**Our Case Number:** ABP-317660-23

**Re:** Bus Connects Kimmage to City Centre core bus corridor scheme  
Kimmage, Dublin

## **Bus Connects Dublin - Kimmage to City Centre Core Bus Corridor Scheme**

**Bord Pleanála Case reference: HA29N.317660**

Programme Title BUSCONNECTS DUBLIN CORE BUS CORRIDORS INFRASTRUCTURE WORKS				
Drawing Title KIMMAGE TO CITY CENTRE CORE BUS CORRIDOR SCHEME GENERAL ARRANGEMENT				
Drawing File Name BCIDD-ROT-GEO_GA-0011_XX_00-DR-CR-0004	Sheet Number 04 of 14	Status A	Rev M01

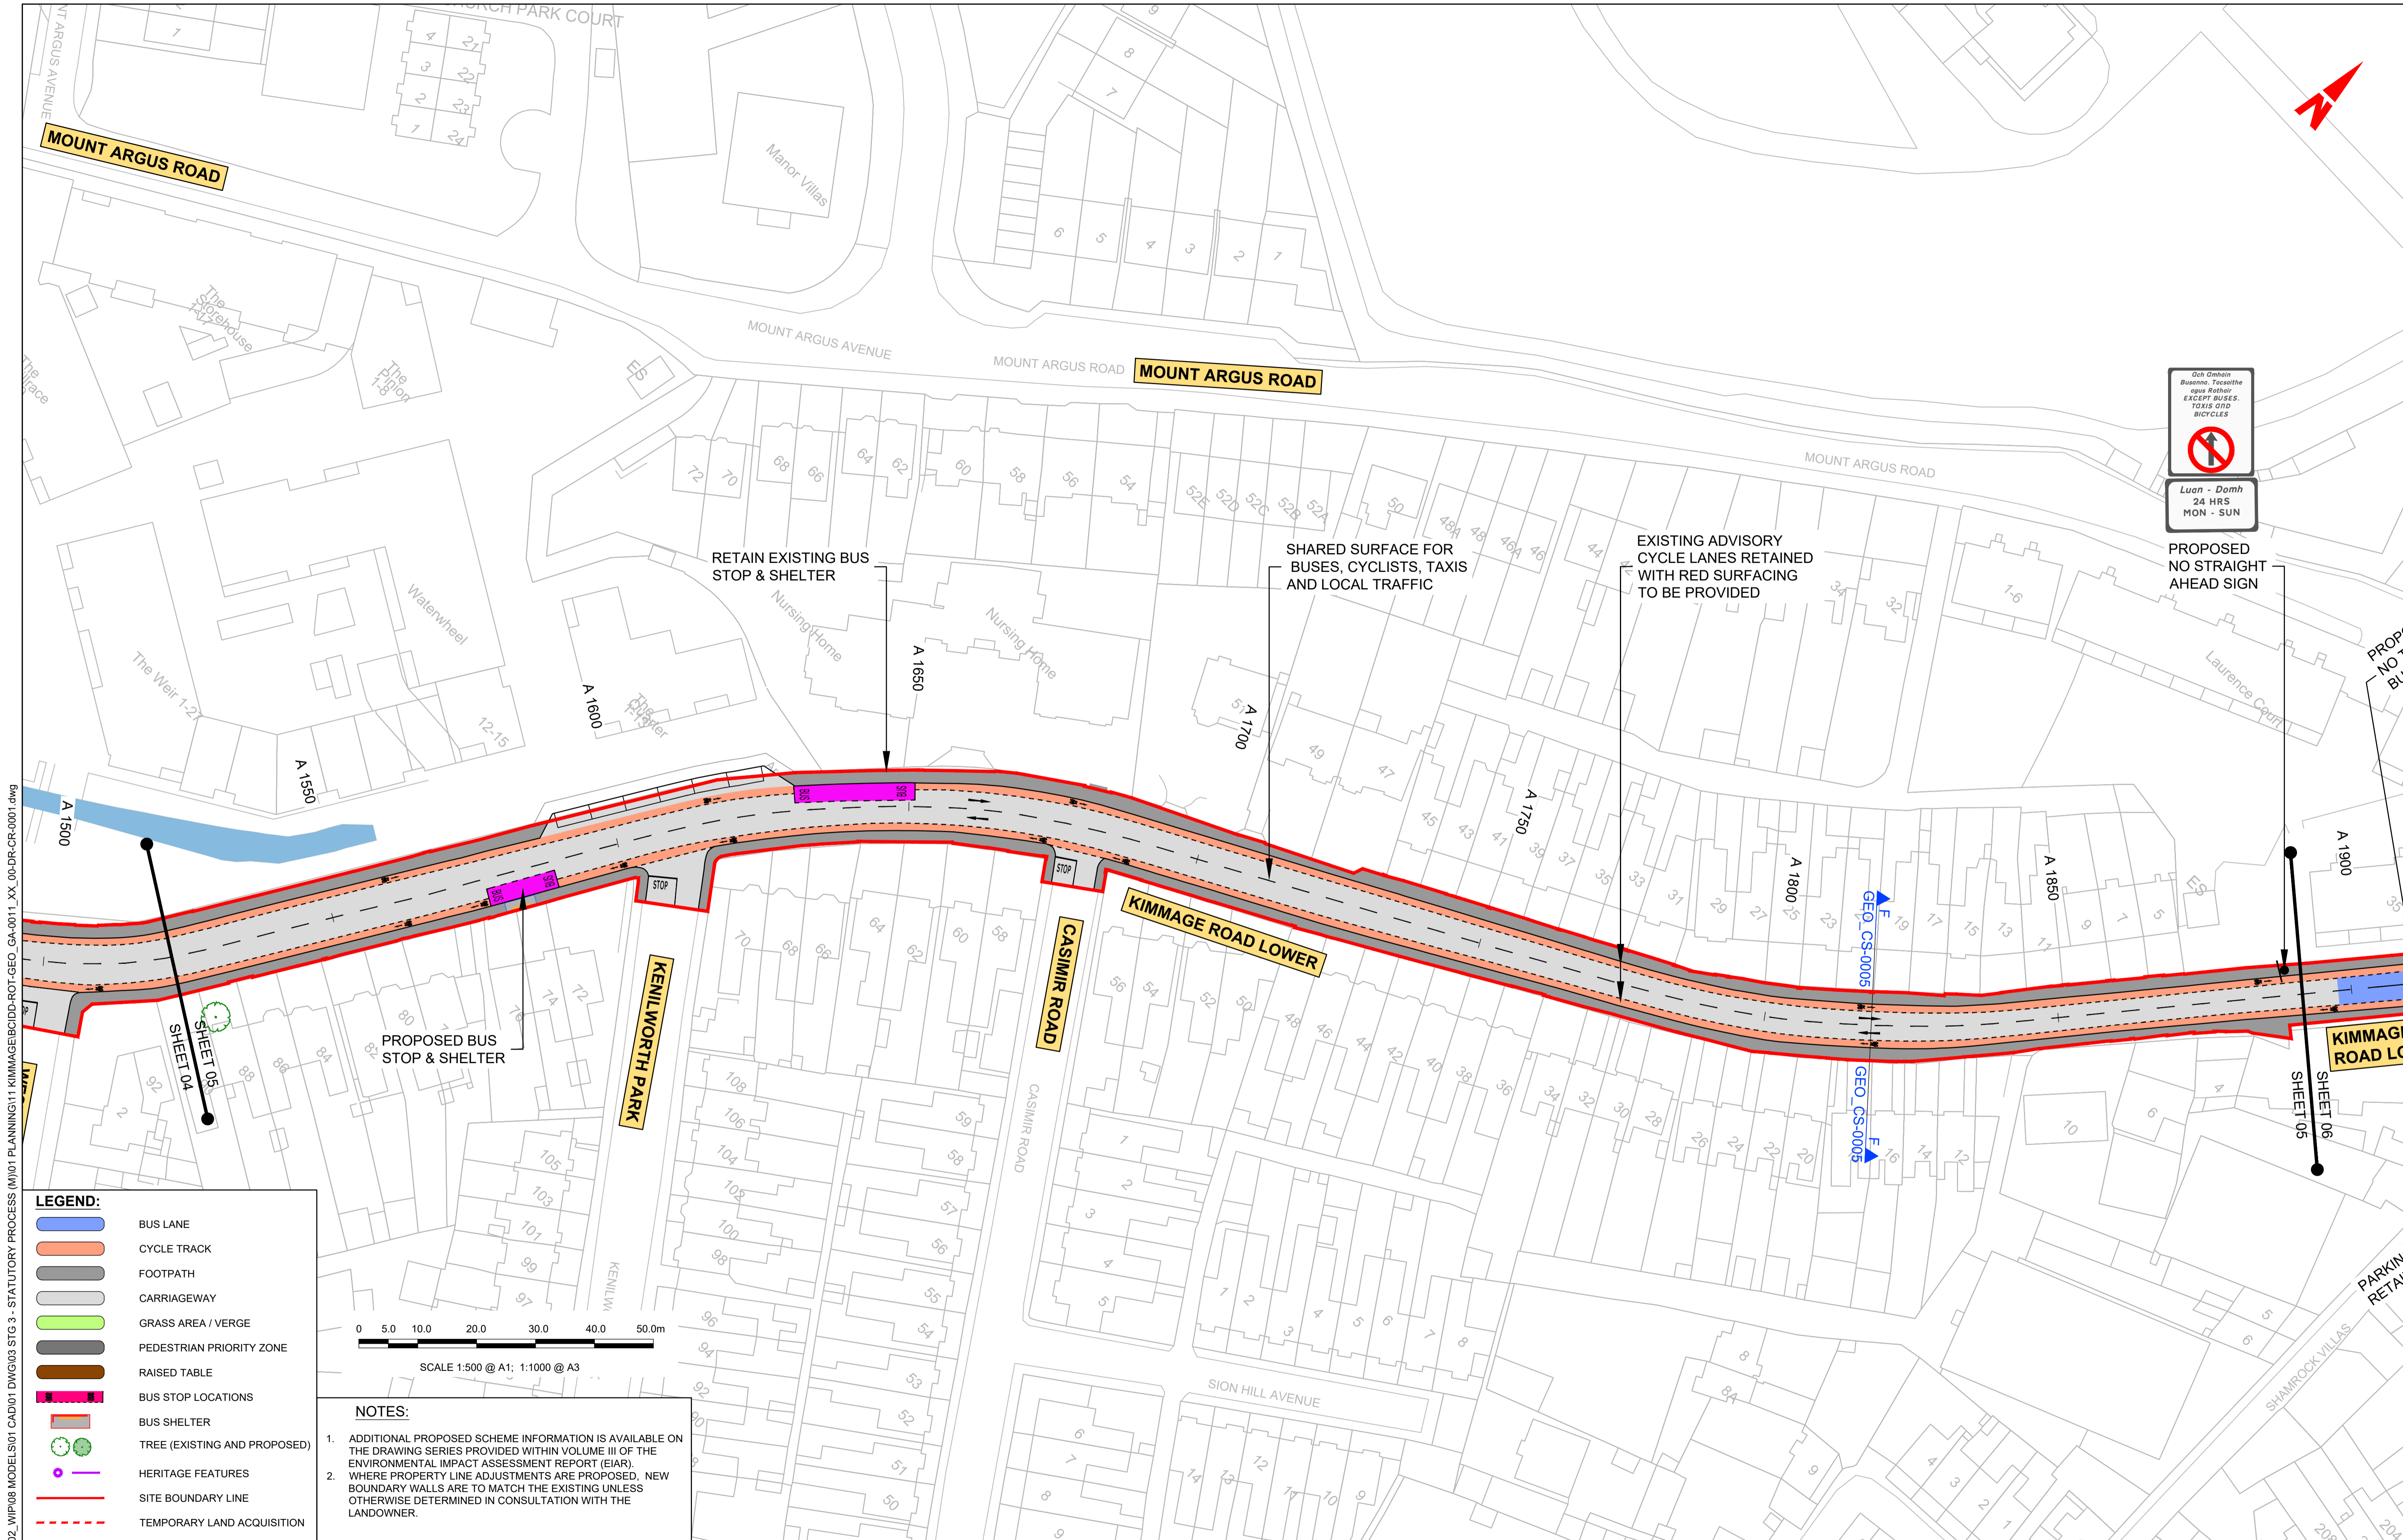
- The proposed construction of a bus stop shelter at bus stop 2391, Priory Road, is impractical due to the narrow width of the pavement at this location. Its introduction will lead to the obstruction of movement of pedestrians including those using mobility vehicles and buggies, (see Appendix 3).

**Bus Stop number 2391 - Shelter located at Priors Road – OBJECTION:**

- The proposed introduction of this Bus shelter is impractical due to the narrow width of the pavement at this location. Its introduction will lead to obstruction of movement of pedestrians including those using mobility vehicles and buggies.

**I request that the developers are instructed not to proceed with plans to build a bus shelter at this location**

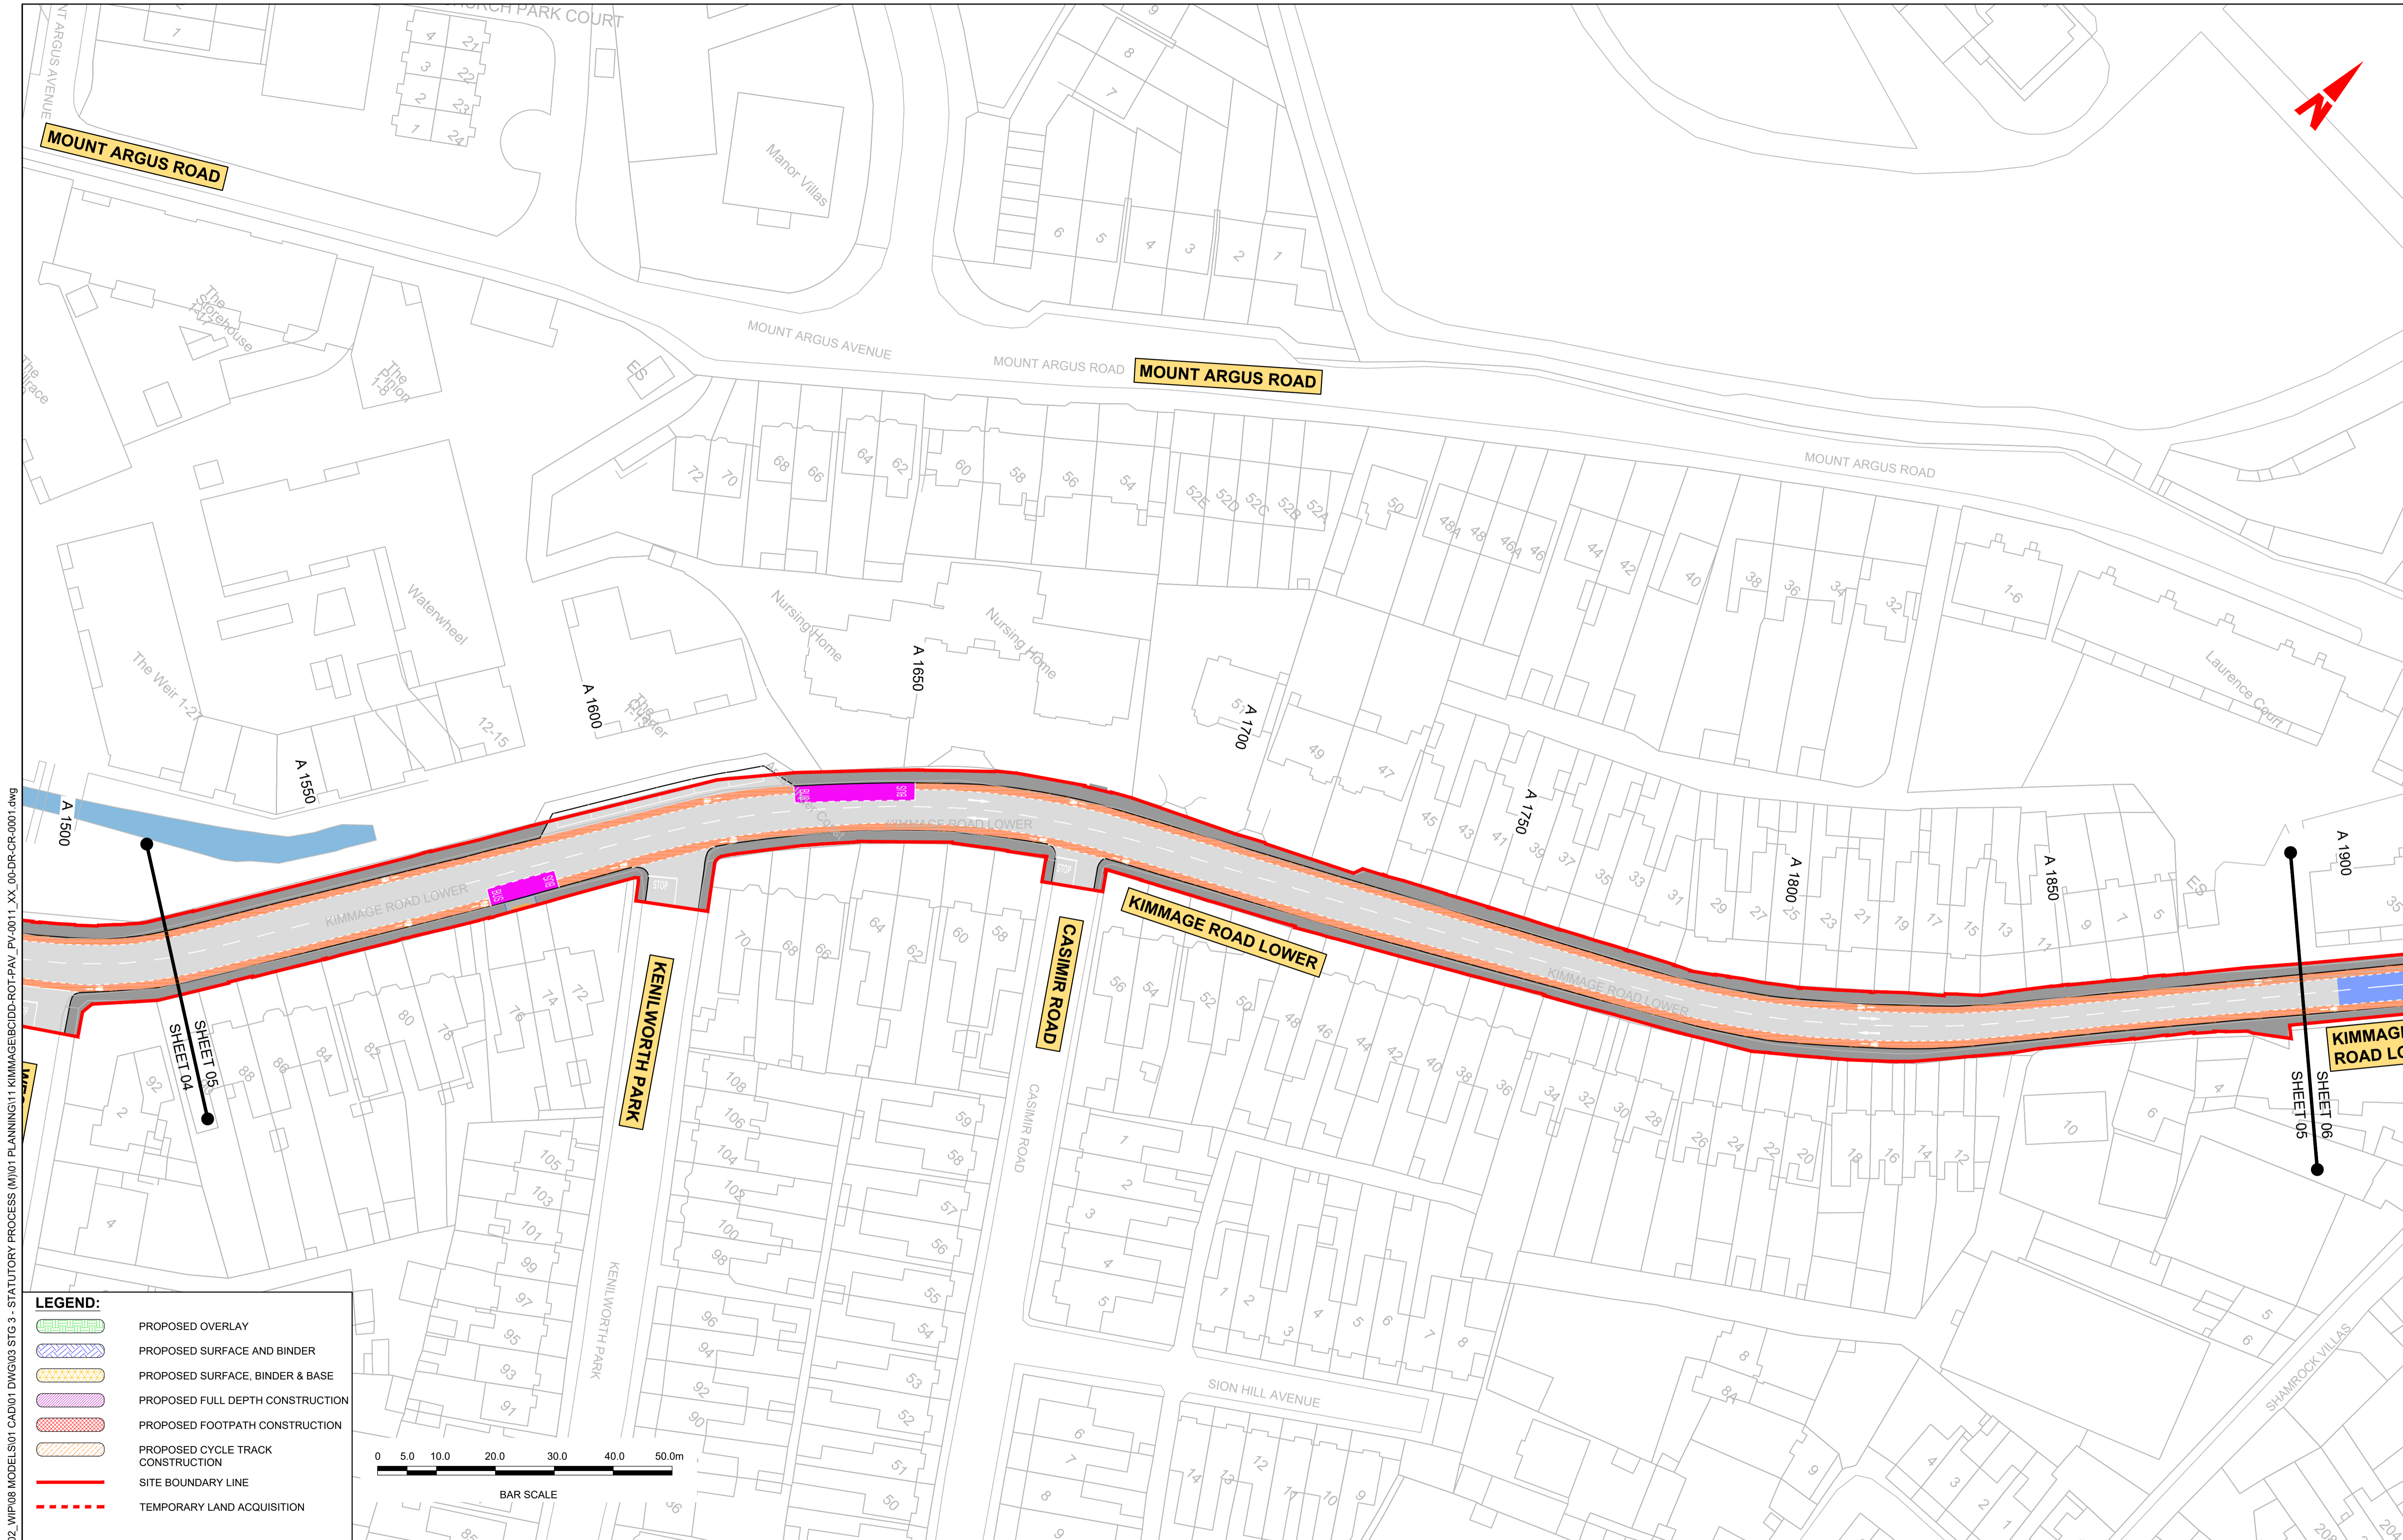
- The development plans propose additional raised paving on the section of Kimmage Road Lower from Numbers 126 to 136. Outside of major road junctions this is the only section of the entire Kimmage Road Lower where such additional raised paving is proposed. It appears to be a wholly unnecessary and overbearing piece of development. The gap between these proposed two (raised) pavements is too narrow to allow for unencumbered access and egress to and from a lane (located between numbers 128C and 130 Kimmage Road Lower) which is used for vehicular rear access for up to c.28\* properties, with that lane being the **ONLY FRONT and PRIMARY** vehicular (and home occupants) access for properties 128a, 128b, 128C, 128D and 128E Kimmage Road Lower. This obstruction means that vehicles will not have enough room to turn into and out of the lane and it will lead to those vehicles having to drive into oncoming traffic to effect that turning. (see **Appendix 1**)

*\*Numbers 128-152 Kimmage Road Lower and numbers 14-23 Larkfield Avenue.*
- The imposition of the standalone raised pavements, from numbers 126 to 136 Kimmage Road Lower, segregating the cycle lane from the road, effectively prevents service vehicles, such as refuse collection, from directly accessing the related properties. It will create difficulties for Waste removal companies servicing properties numbered from 126 to 136

**I request that the developers are instructed to modify their plans and remove the proposed section of unnecessary paving from the proposed development. The proposed section of paving is approximately 50m long and as stated above appears to be the only such section outside of major junctions. It appears to be a wholly unnecessary and overbearing piece of development.**

**OBJECTION:**  
 The introduction of raised pavements along this section of Lower Kimmage Road appears to be random and sporadic and there is no discernible reason as to why they are placed at these specific positions. Their presence does however lead to problems and any notional benefits are outweighed by those problems.

The introduction of **raised pavements** along this section of Lower Kimmage Road appears to be random and sporadic and there is no discernible reason as to why they are placed at these positions. **Their presence does however lead to problems and any notional benefits are outweighed by those problems:**

1. The gap between these proposed two (raised) pavements is too narrow to allow for unencumbered access and egress to and from the lane which is used for vehicular rear access for up to c.28 properties\*, with that lane being the **ONLY FRONT and PRIMARY** vehicular (and home occupants) access for properties 128D and 128E Kimmage Road Lower. This obstruction means that vehicles will not have enough room to turn into and out of the lane and it will lead to those vehicles having driving into oncoming traffic.
2. It will create difficulties for Waste removal companies servicing properties numbered from 128 to 136 Kimmage Road Lower and will result in emptied bins being further strewn along the road. This practice (of not placing bins immediately outside of owning property) **WILL** be exasperated, leading to pedestrian and possibly cyclists movement obstruction.

**Design amendment required:** the proposed raised pavements in front of numbers 126 to 136 Kimmage Road Lower should be removed. Should any alternative structures be proposed, then they too **MUST NOT** give rise to the above identified problems.
